Your Ref: OWPC24244
Our Ref: EP/110/19/PL 27-08-2019
Please ask for:
Mr J Baeza

Variation of condition 5 imposed under EP/145/17/HH relating to window on NW dormer elevation to be obscured glazed, top hung with restricted opening.

9 Nursery Close East Preston

Proposed First Floor Plan
and Section

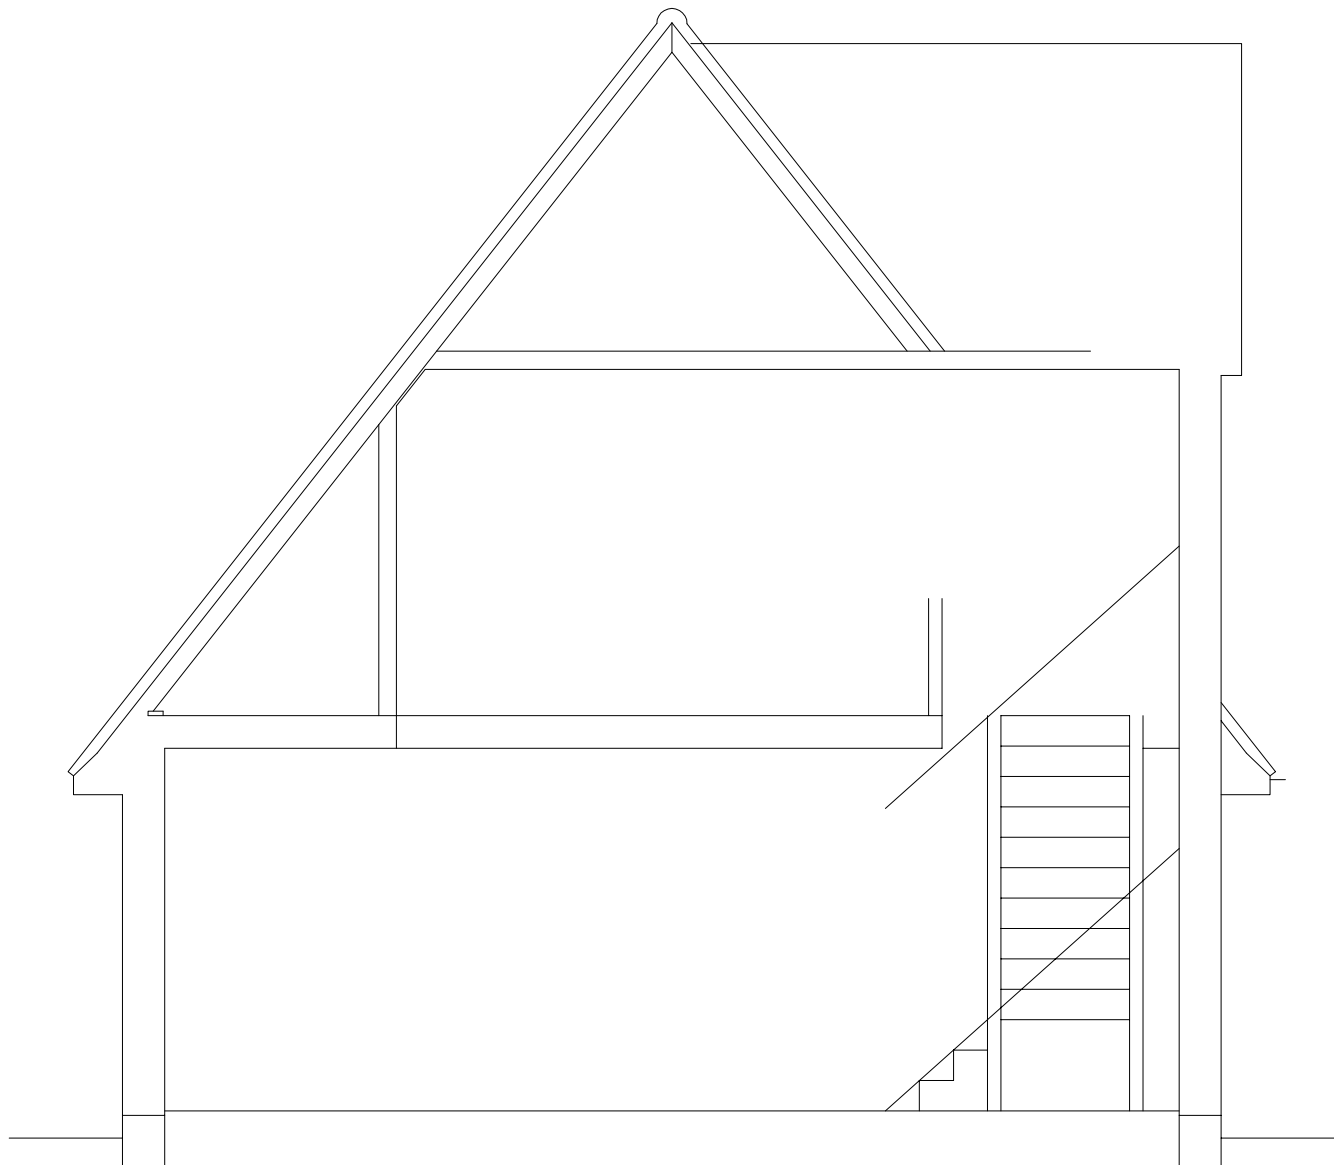
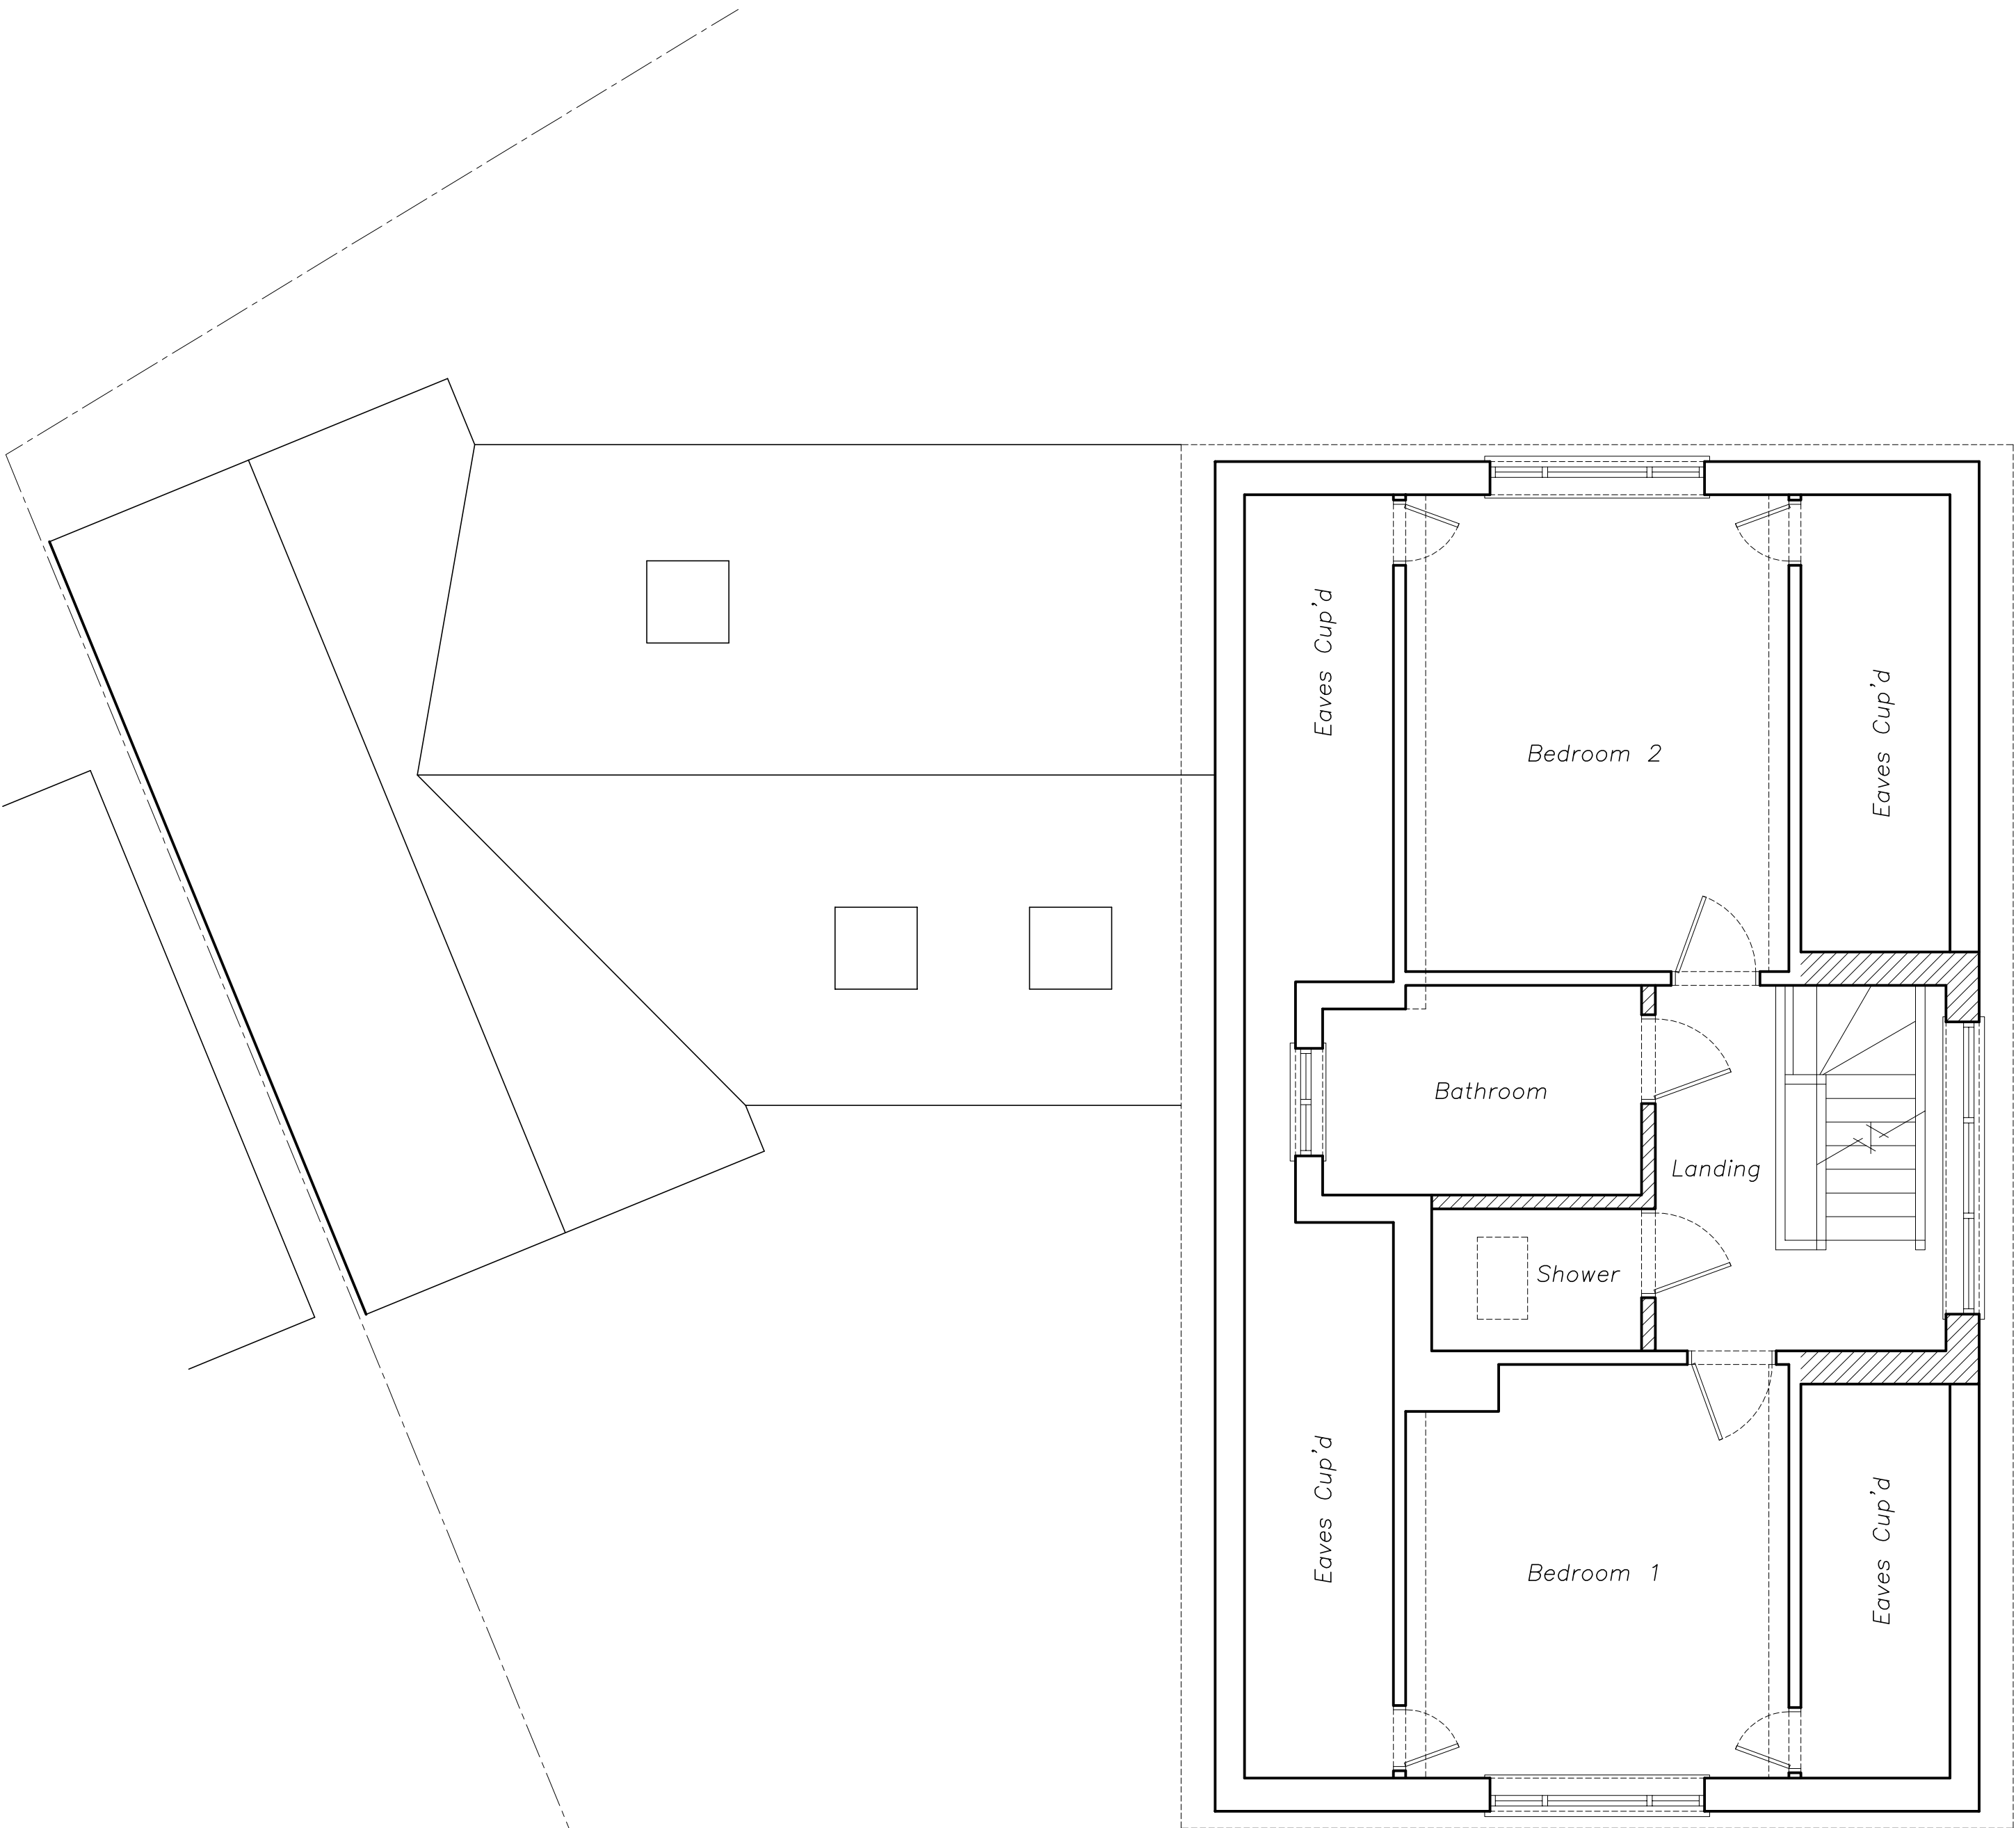
The originally approved arrangement of obscured glass and 1.7m height to opening is standard practice for bathroom windows nationwide. The applicant has offered no valid reason why there should be a retrospective variation in this case, apart from the fact that the intention to submit a revised application prior to construction was forgotten. The installed window opens at a height of 1m from the floor and, even with the proposed restriction on opening, will allow people to be seen inside the building from ground level and similarly overlook our patio, therefore impinging on our privacy
